RICHARD MAWDSLEY

WRITTEN REPRESENTATION

HIGHWAYS ENGLAND'S RESPONSE

M4 JUNCTION 3 TO 12 EXPANSION OBJECTION

Gantry Reference G9-10

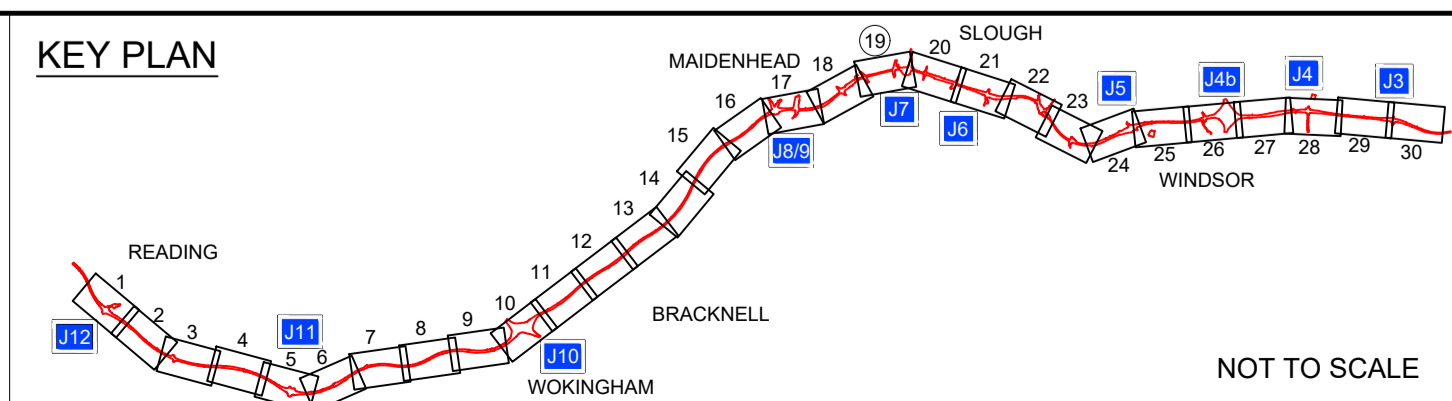
- 2.1 *Removal of trees: To facilitate the new Thames bridge at Bray, the TPO protected trees and vegetation will be removed. These trees serve as a vital habitat for wildlife but also protect residents. The trees have many virtues in protecting residents from the effects of the motorway. Firstly, they are a direct barrier to sound and light pollution. Secondly, trees provide a filtering effect on some of the carbon gases released in car fumes. Other air pollutants also need consideration, particularly following recent research into diesel emissions. The following academic paper produced by the environment agency and county*

council highway departments details the effects of pollution close to the edge of the motorway (<http://core.ac.uk/download/pdf/62011.pdf>). The reduction in space between the edge of the motorway, and the local houses as well as the river should be of greater concern and should receive more consideration than is currently the case.

- 2.1.1 The vegetation clearance and associated mitigation proposals for the River Thames location at Bray are provided in the Engineering and Design Report, Annex A2, Vegetation Clearance Drawing Sheet 19 (Application Document Reference 7-4) and Annex A1, Environmental Masterplan Drawing Sheet 19. It is also recognised in paragraph 8.8.14 of the ES (Application Document Reference 6-1) that some trees covered by a TPO will be affected. Whilst vegetation clearance will be required, extensive replacement planting is proposed. As set out in Table 8.2 of the ES (Application Document Reference 6-1), the landscape and visual effects during and immediately following construction are assessed to be moderate adverse, reducing to slight adverse by the Design Year (15 years after construction) due to the establishment of planting. With regard to trees protected by TPO, in the event that such trees are affected, measures will be adopted to agree the replacement planting and or tree work of any affected trees with the local planning authority, as stated in paragraph 8.6.2 of the CEMP. The vegetation clearance required to widen Thames Bray bridge includes semi-natural broadleaf woodland, plantation broadleaf woodland, and dense/continuous scrub. These habitat types and their value are described in paragraphs 4.1.1 to 4.1.4 in Appendix 9.1 to the ES (Application Document Reference 6-3) and their location is shown in Drawing 9.2 Sheet 41 (Application Document Reference 6-2). Ancient semi-natural broadleaf woodland or semi-natural broadleaf woodland on the site of ancient woodland is considered to be of likely intrinsic biodiversity value at the national level. However, the broadleaf woodland near Thames Bray bridge is not included on the Ancient Woodland Inventory published by Natural England. Stands of semi-natural woodland that are not ancient semi-natural woodland or replanted ancient woodland, plantation woodland and scrub are considered to be of local biodiversity value.

- 2.1.2 The trees within these habitats will support a range of wildlife, including birds, small mammals and insects. However, the loss of individual trees will not significantly affect biodiversity in the area. Furthermore, the areas to be cleared

of vegetation for temporary construction use will be replanted, including linear belts of trees and shrubs, as shown on the Vegetation Clearance and Environmental Masterplan drawings Sheet 19 in the Engineering and Design Report (Application Document Reference 7-4). Overall, the significance of effect of vegetation removal on wildlife is considered to be neutral.
